# MEMO

## RE: Oakdale West Estate Stage 3 Development (SSD-9794683) – Response to TfNSW RFI

**Table 1: TfNSW Comments (18/03/2021) and Ason Group Response**

Proposed Industrial Facility -Proposed Building 2A

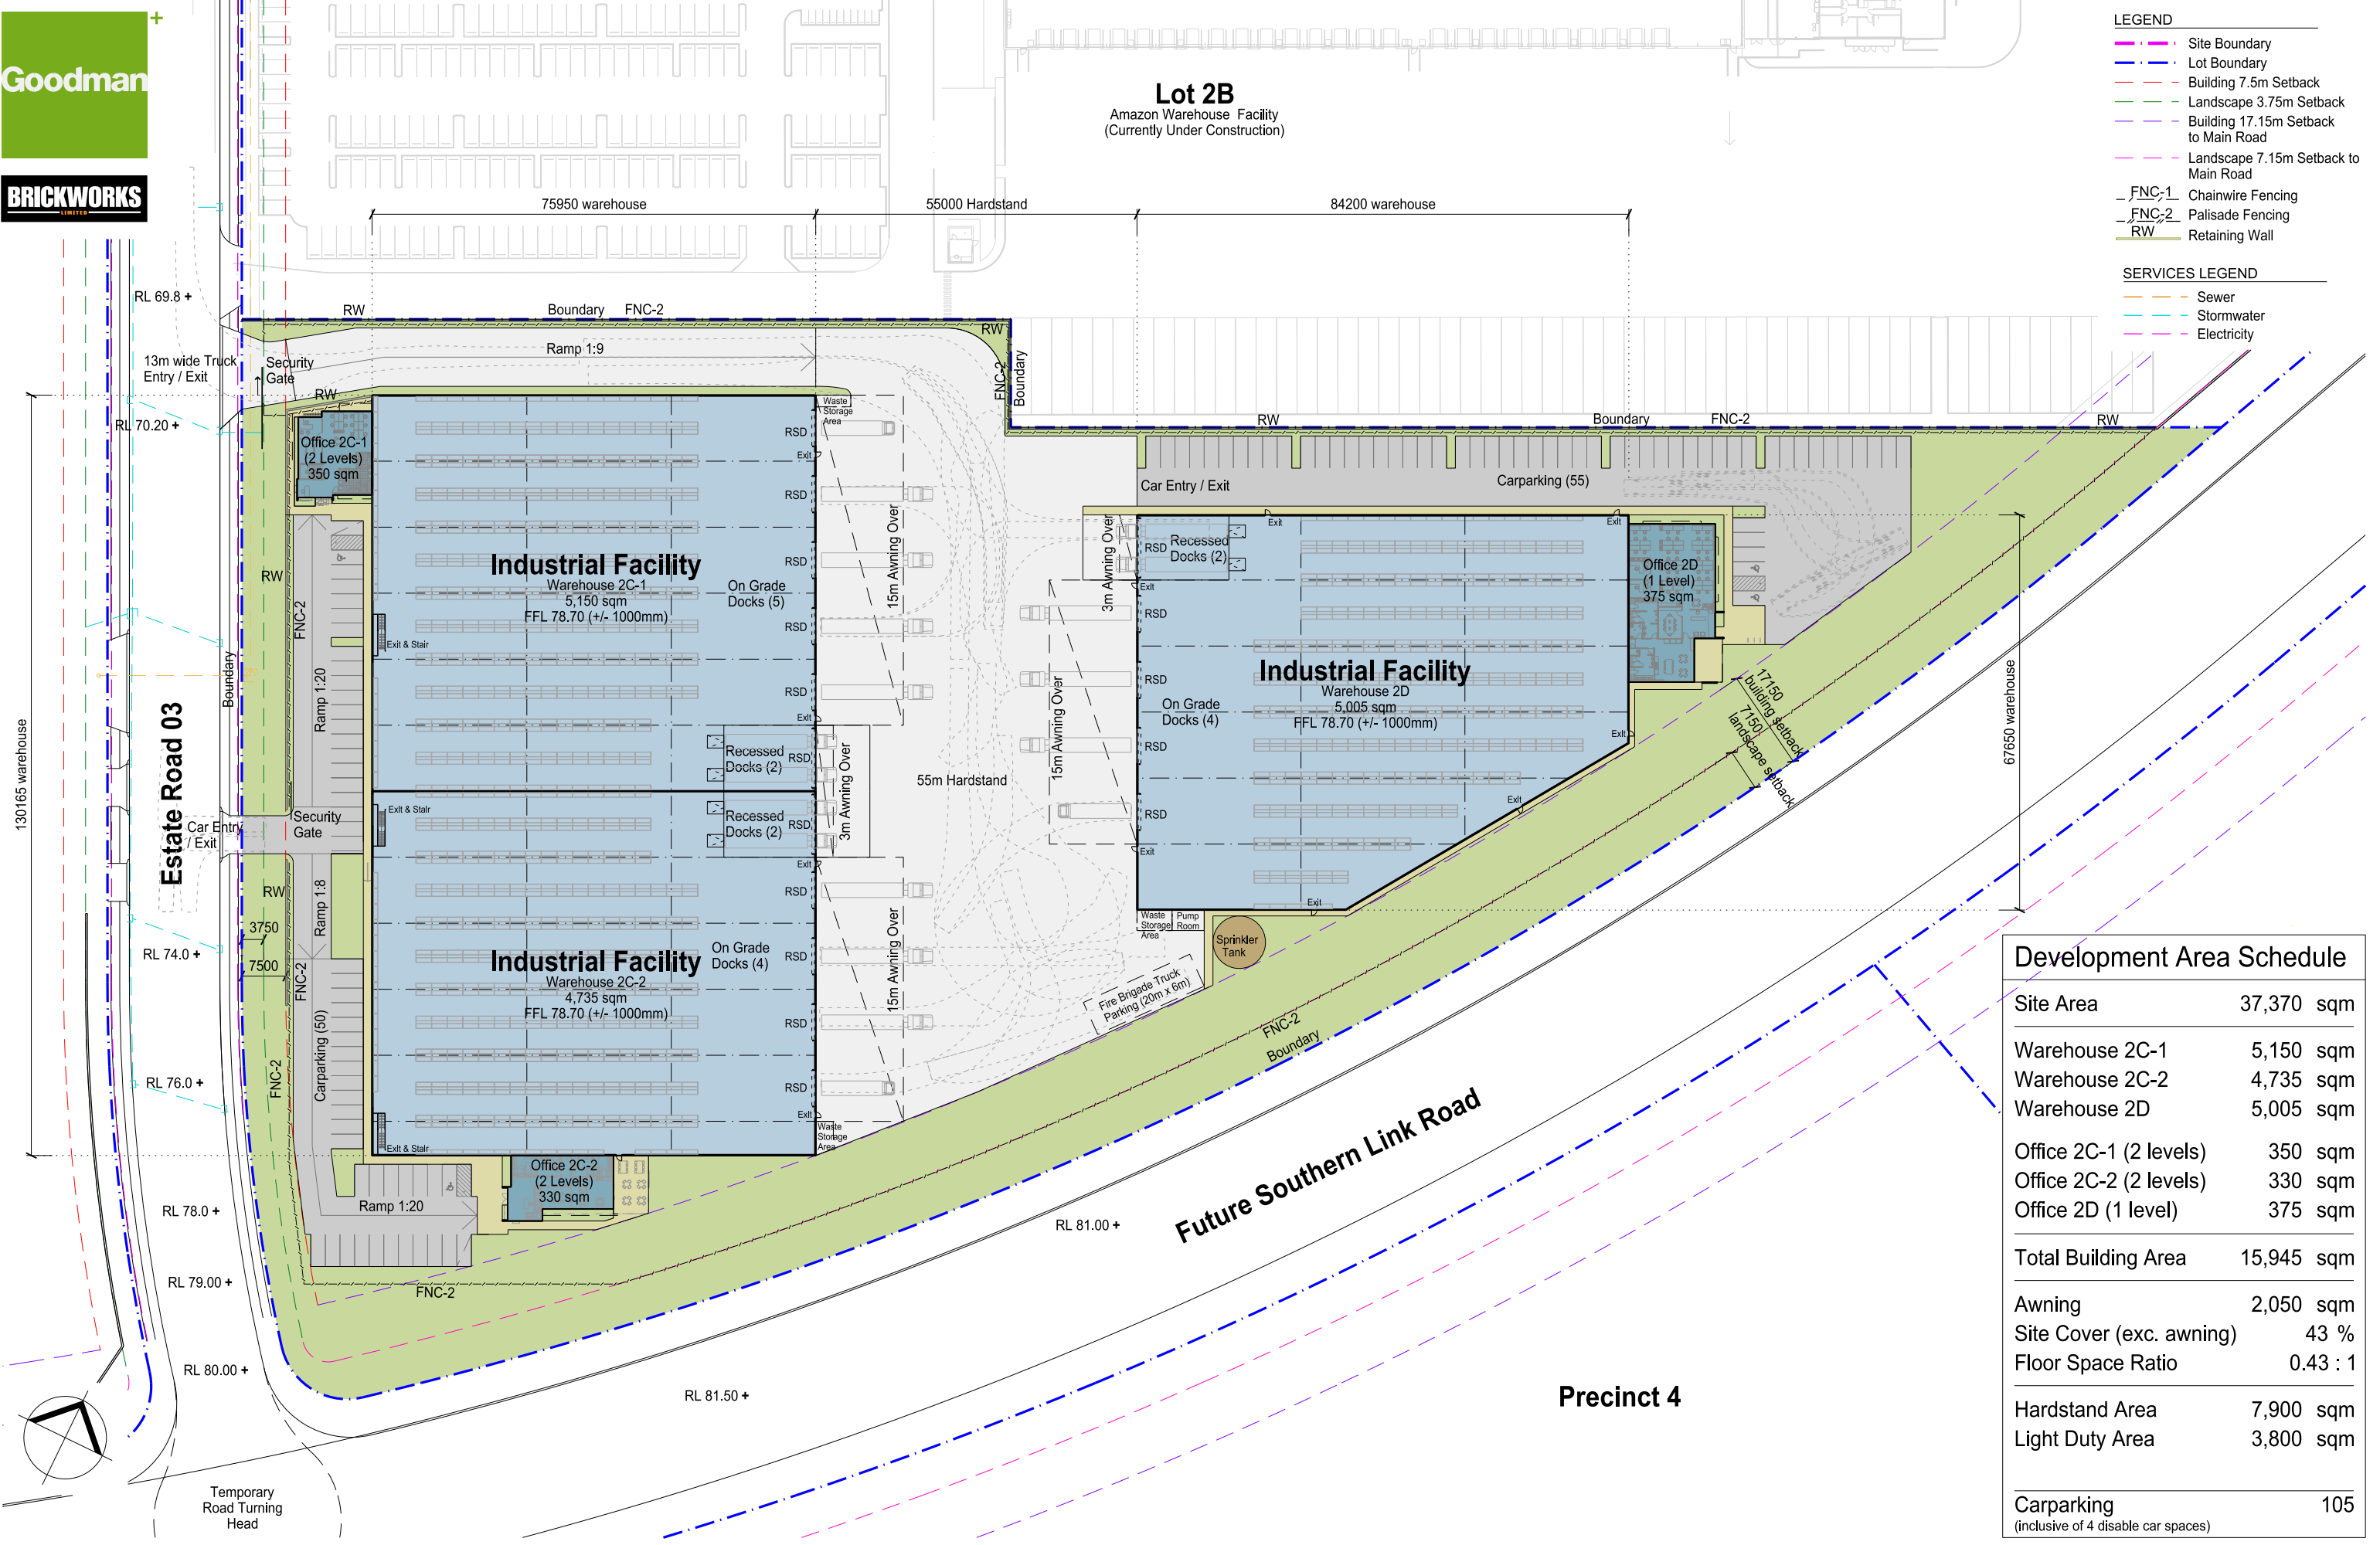
Item No.	TfNSW Comment	Ason Group Response
11	<p><b><u>Comment:</u></b></p> <p>The swept path plans for Building 2A indicate that simultaneous entry/exit cannot be achieved with the largest vehicles. This can lead to conflict points at the access to the lots where 2 opposing vehicles are attempting to use these accesses at the same time.</p> <p><b><u>Recommendation:</u></b></p> <p>The design of the access points should allow for simultaneous entry/exit movements of the largest vehicle. The swept path of the longest vehicle entering and exiting the subject site, shall be in accordance with AUSTRROADS and to the satisfaction of Council.</p>	<p>Site access for Building 2A has been widened to allow for simultaneous entry/exit movements of super B-doubles. It now provides separate entry and exit points with 2 metres median for pedestrian refuge.</p> <p>Relevant swept path analysis is included in Attachment 2.</p> <p>It is noted that, in order to provide this separate entry and exit at Building 2A, the revised scheme has resulted in a total reduction of 8 car parking spaces, which indicates a deficit of 7 car parking spaces.</p> <p>In general, staff arrival / departure time of warehouses are scheduled staggered; therefore, it is expected that the proposed car parking provision can still sufficiently accommodate on-site parking demand.</p> <p>Furthermore, additional car parking spaces can be provided as provisional spaces within hardstand area based on actual on-site parking demand of future tenant, if required.</p>

12	<p><b><u>Comment:</u></b></p> <p>In addition to the above point, it is noted that the design of the internal road network within Building 2A does not allow for continuous 2-way flow.</p> <p><b><u>Recommendation:</u></b></p> <p>The design should be updated to allow for the continual 2-way flow along the main access road, in particular on the corners where there is restricted sight distance to the satisfaction of Council.</p>	<p>Site Plan for Building 2A has been updated to allow for continuous 2-way flow of super B-doubles.</p> <p>Relevant swept path analysis is included in Attachment 2.</p>
